Mr Victor Grayson, Development Management Master Planner
Kirklees Planners

Objection to Planning Application 2024/70/90991/E (Yorkshire Country Properties now called Vivly)

Sheet Name: Proposed site sections

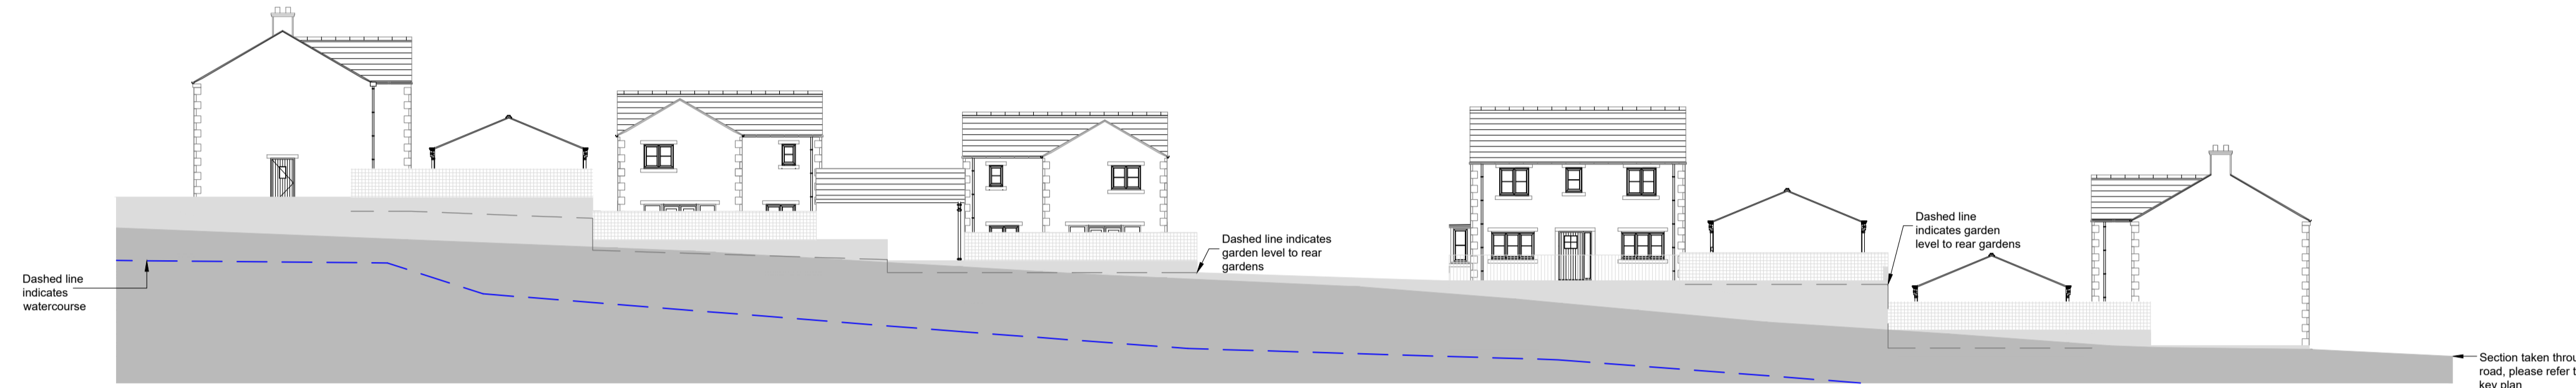
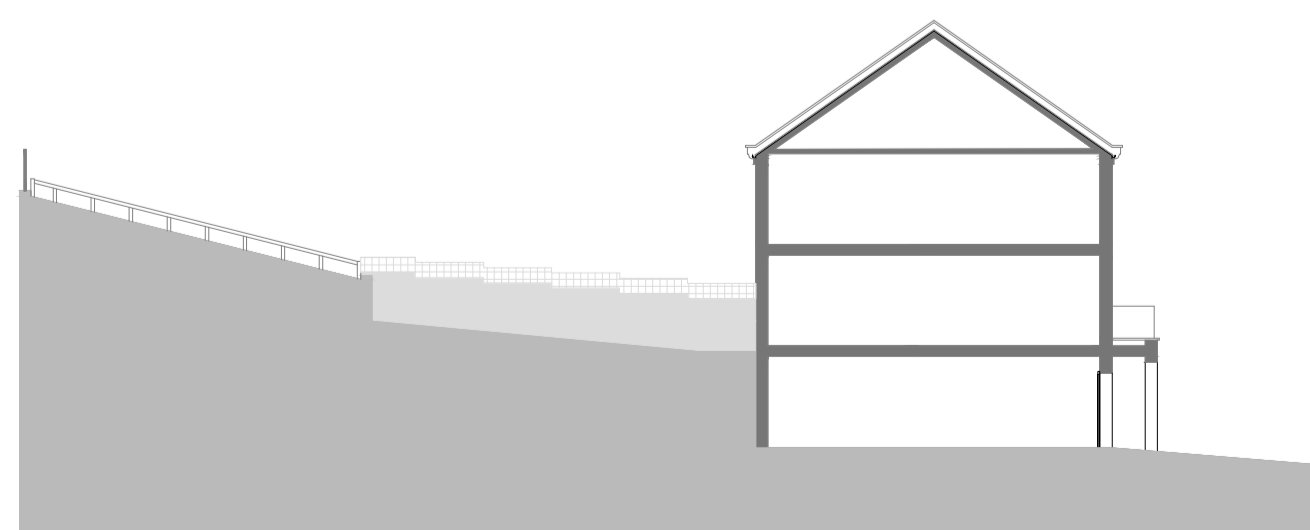
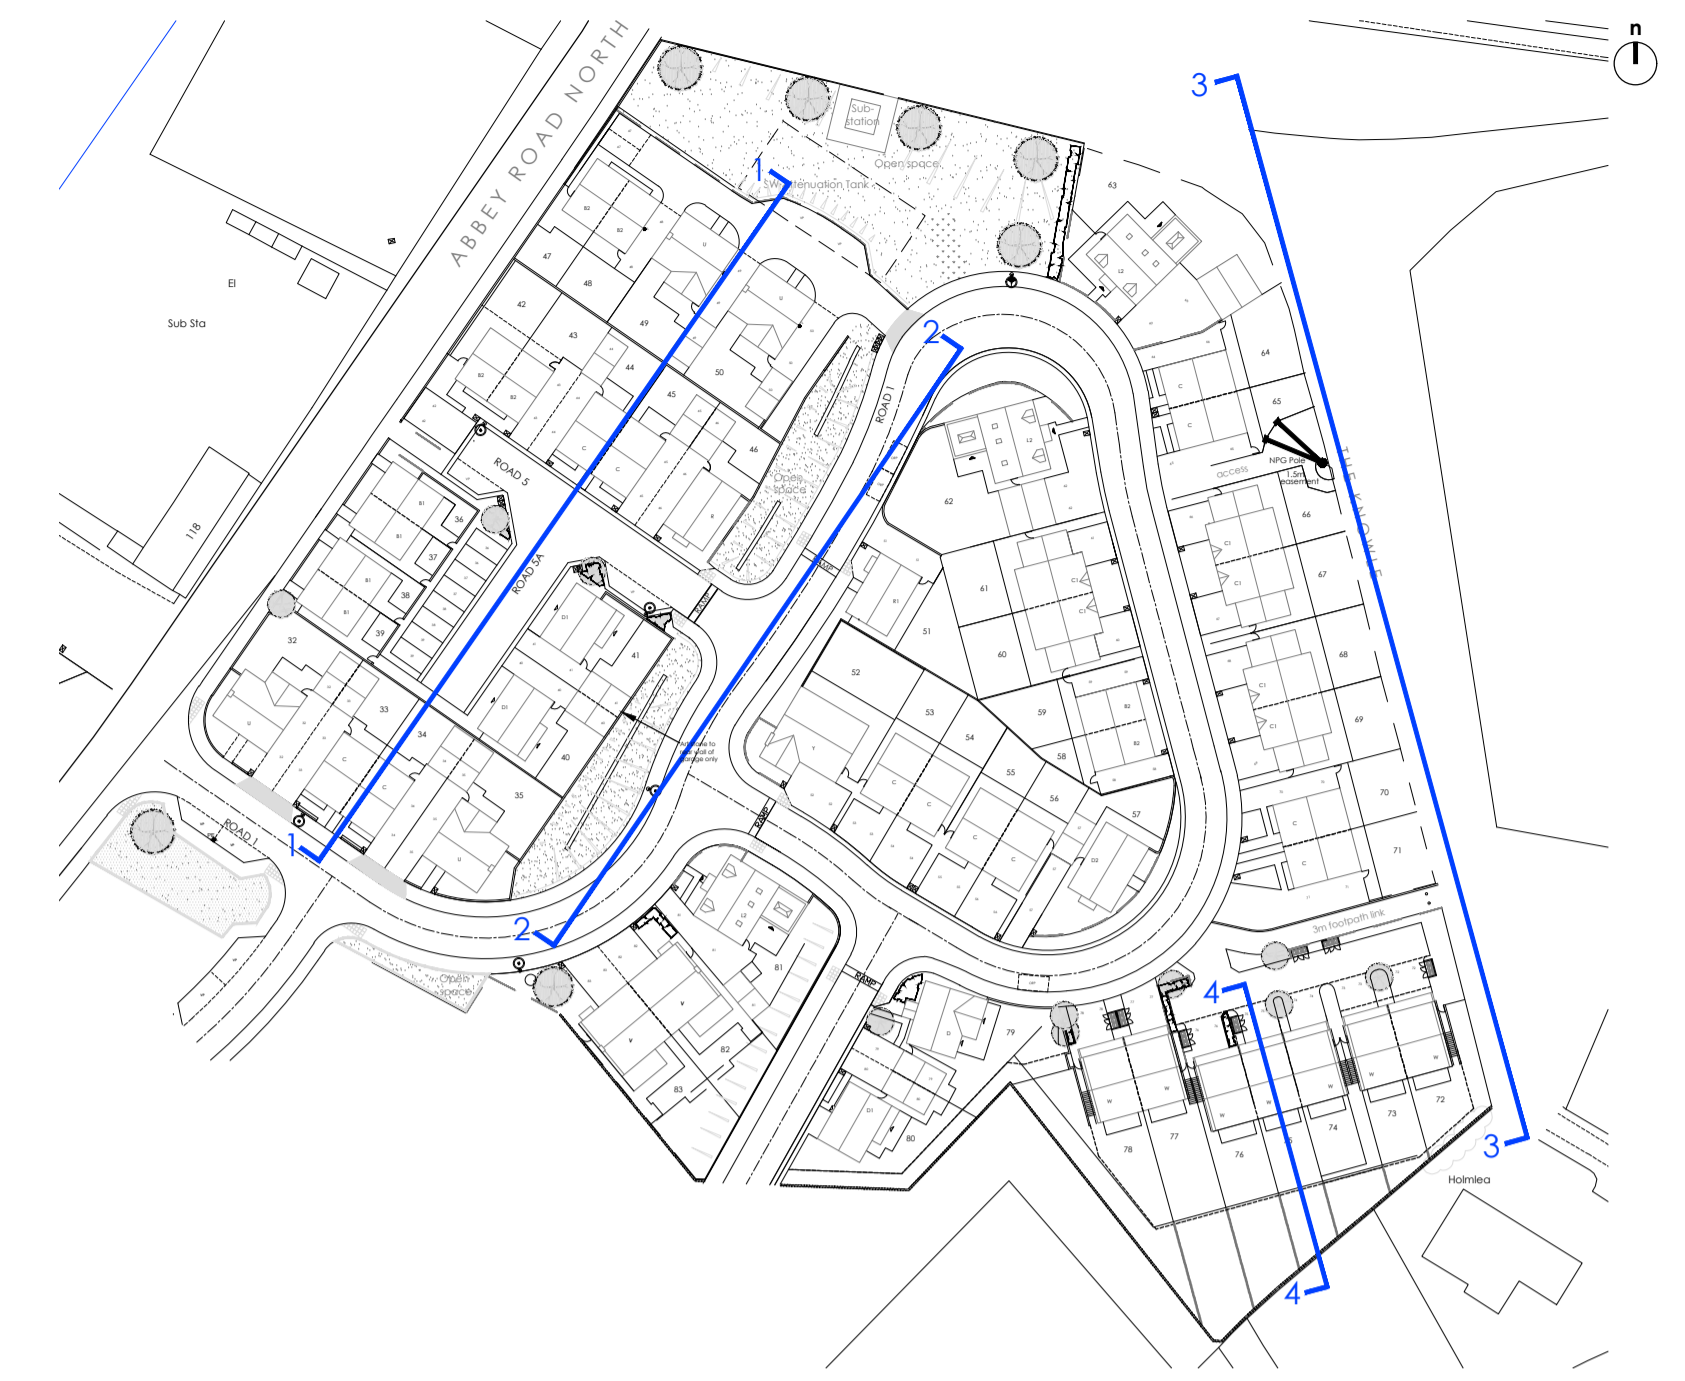
The applicant claims that the required adopted road can only be achieved at a gradient of 1 in 12.5, asserting that Kirklees Highways will not adopt roads with a steeper gradient. I believe this is not accurate because many recently approved sites within Kirklees have gradients steeper than 1:10, such as those in Denby Dale and Netherthong, another Vivly site.

I make it clear that a 1:10 gradient for Road 6 would solve all the access problems.

113 This is a cross section of the Road Header seen on the X-X profile above.

117 The header is 25m wide with a slow gradient of 1:31.

118 At the highest point on the header to the east, it is 2m (181.46–179.4) below ground level.

119 Going east toward the 7 plots, the ground level continues to rise further. In the next 25m, the
120 ground is 4m above the header. As seen on the plan in red, a road with a gradient of 1:12.5
121 cannot keep up with the rising ground level.

122 If the proposed plans were approved, gaining access at adoptable standards would require the
123 removal of thousands of tonnes of heavy clay and the construction of large, unsightly retaining
124 walls. This would be a very poor use of land and could result in long road runs to lower the
125 gradients. Perhaps some compromise could be reached?
